LOCAL IMPACT REPORT

Manston Airport DCO (PINS Reference TR020002)

Produced by Kent County Council

Application by RiverOak Strategic Partners Ltd for an Order
Granting Development Consent for the upgrade and reopening of
Manston Airport
Local Impact Report for Kent County Council Highways and
Transportation
January 2019 PL/12679

ANNEX 3
PRoW PLAN

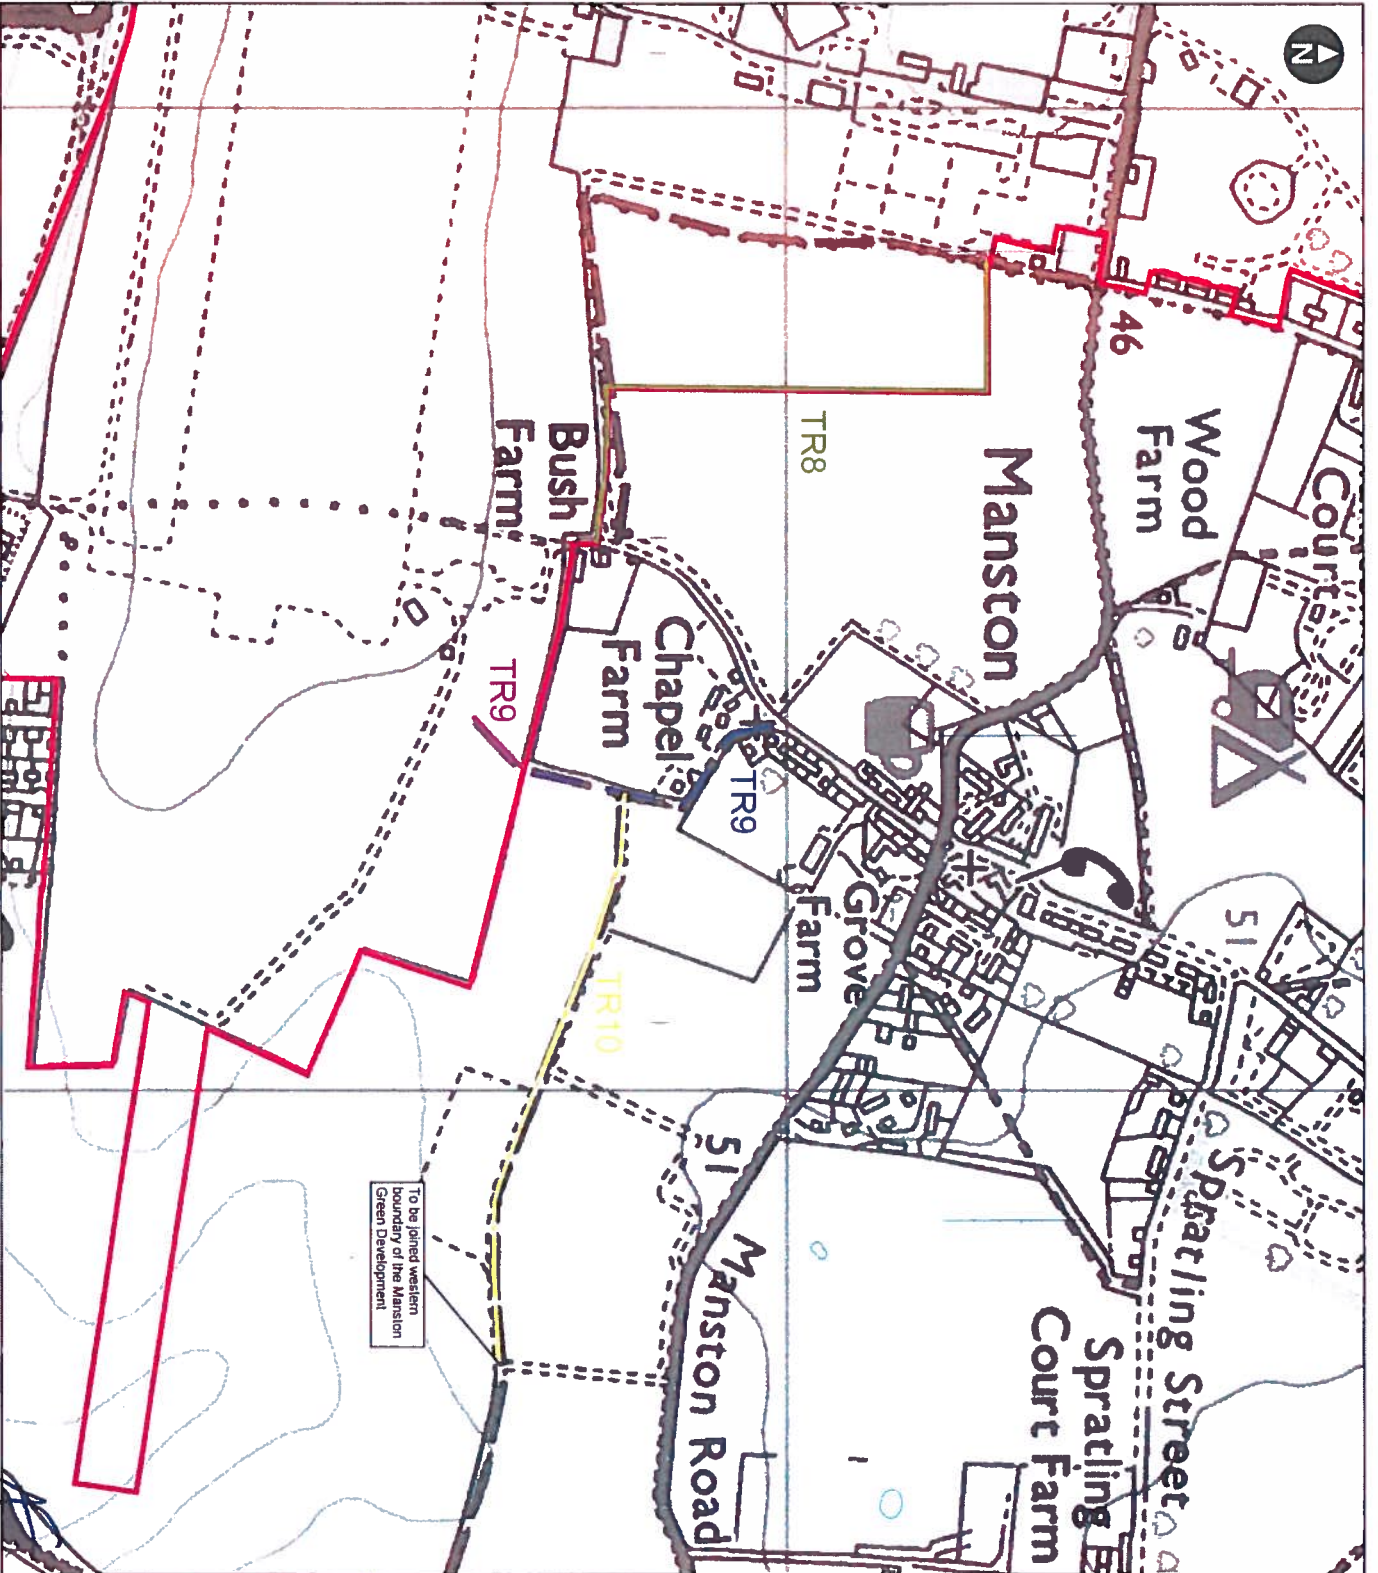
- 3.1 The County Council would expect monies to be secured to improve the surface of the existing and diverted bridleways to a minimum width of 3m along the entire length, which will include bridleways TR8 and TR10. KCC can supply a cost for this work.

- 3.2 It is understood from the PROW Management Strategy that bridleway TR8 will be rerouted along the edge of the new proposed perimeter fence of the airport, with the

previous route permanently closed and a new route permanently established. It is requested that contact is made with the KCC PRow and Access Service at the applicant's earliest convenience, to discuss any required route diversions. In respect of ongoing maintenance, it will be expected that the site operators will take on ongoing maintenance responsibilities for any landscaping and enhancements along the bridleway and PRow network.

- 3.3 Hedge or vegetation planting required as screening will need to be at least 2m away from the boundary of the bridleway to ensure that the full width of the bridleway is open and available once the hedge matures, and to facilitate future hedge maintenance, without requiring the closure of the bridleway.
